From:
Sent: 11 May 2026 15:41
To: DC Admin
Subject: Planning application 2026/90930

Please find below comments regarding the proposed extension at 349 Whitehall Road, Wyke, BD12 9DP.

Proposed Other Side Elevation
Scale 1:50@A1

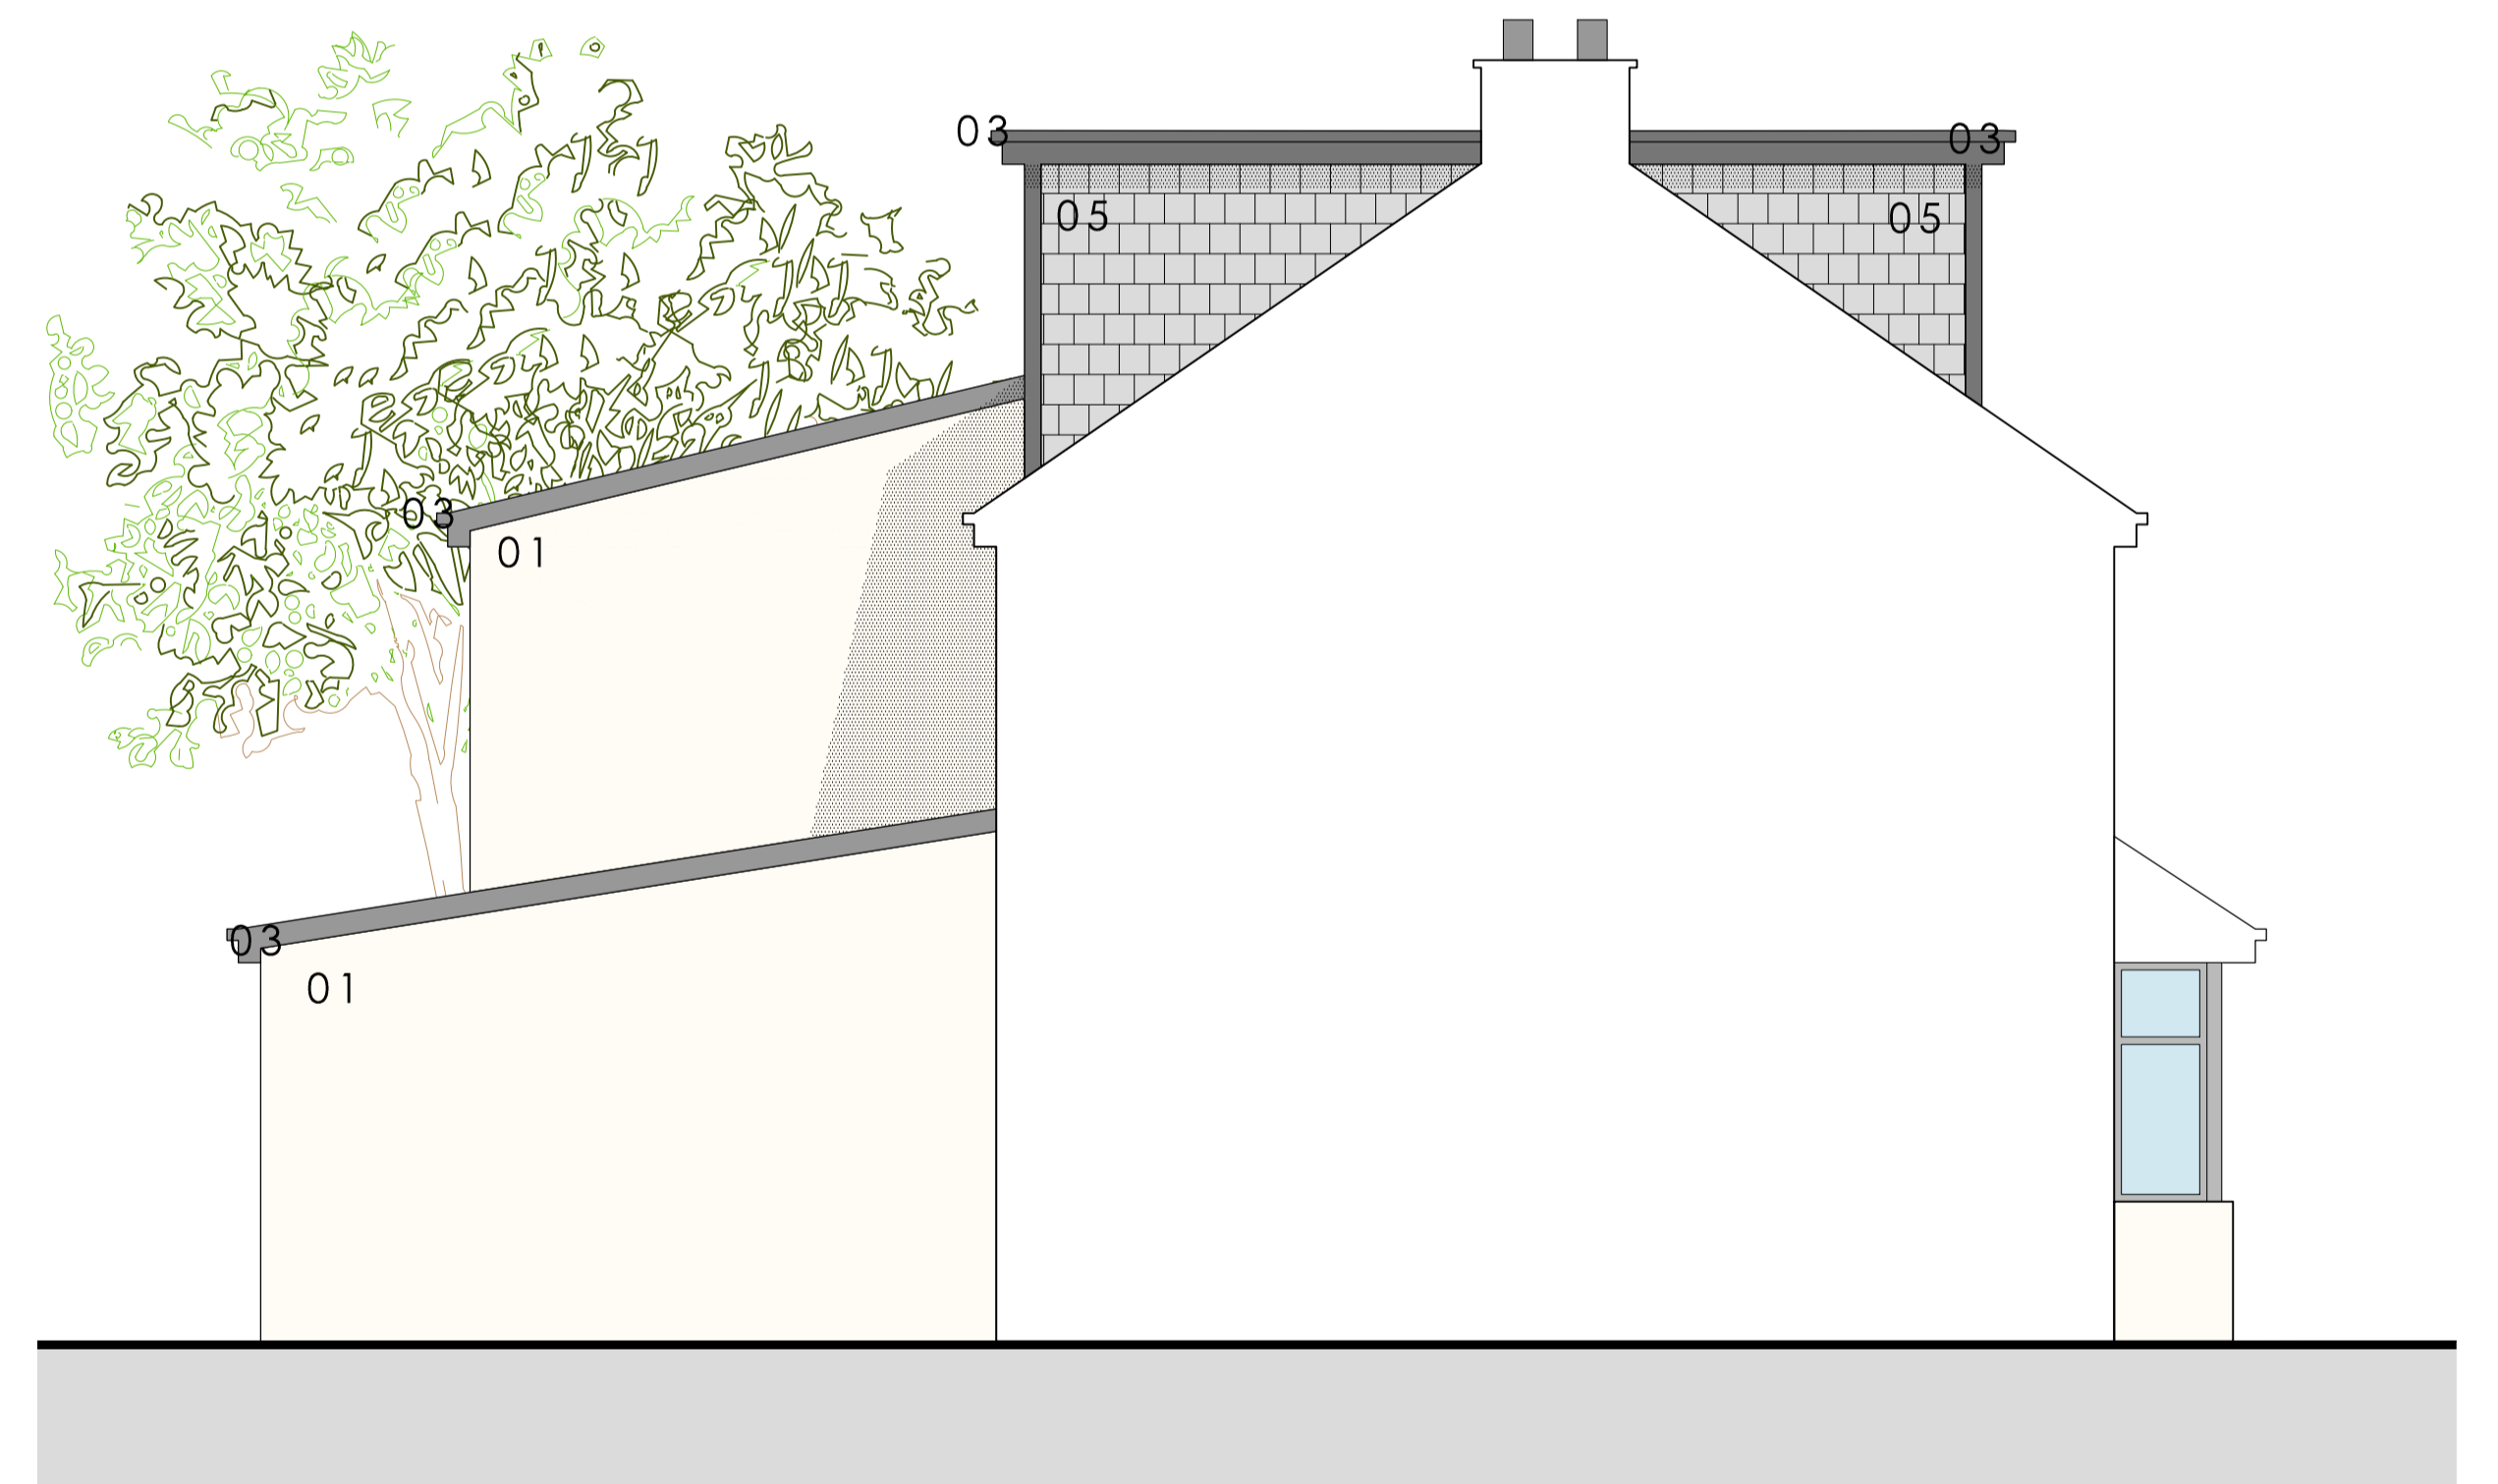
Having viewed the proposed plans for the extension, the property will double the existing property and is too large for the available space. With the Dorma extension it will tower over the existing properties which are small semidetached houses and not be in keeping with the area and look out of place and imposing. Also an invasion of privacy to the surrounding houses. These properties were built for small families.

Although I am not next door the extension is right up to the boundary and being double storey will block any direct sunlight making 351 very dark and if wishing to sell will have a negative effect on their property for proposed buyers.
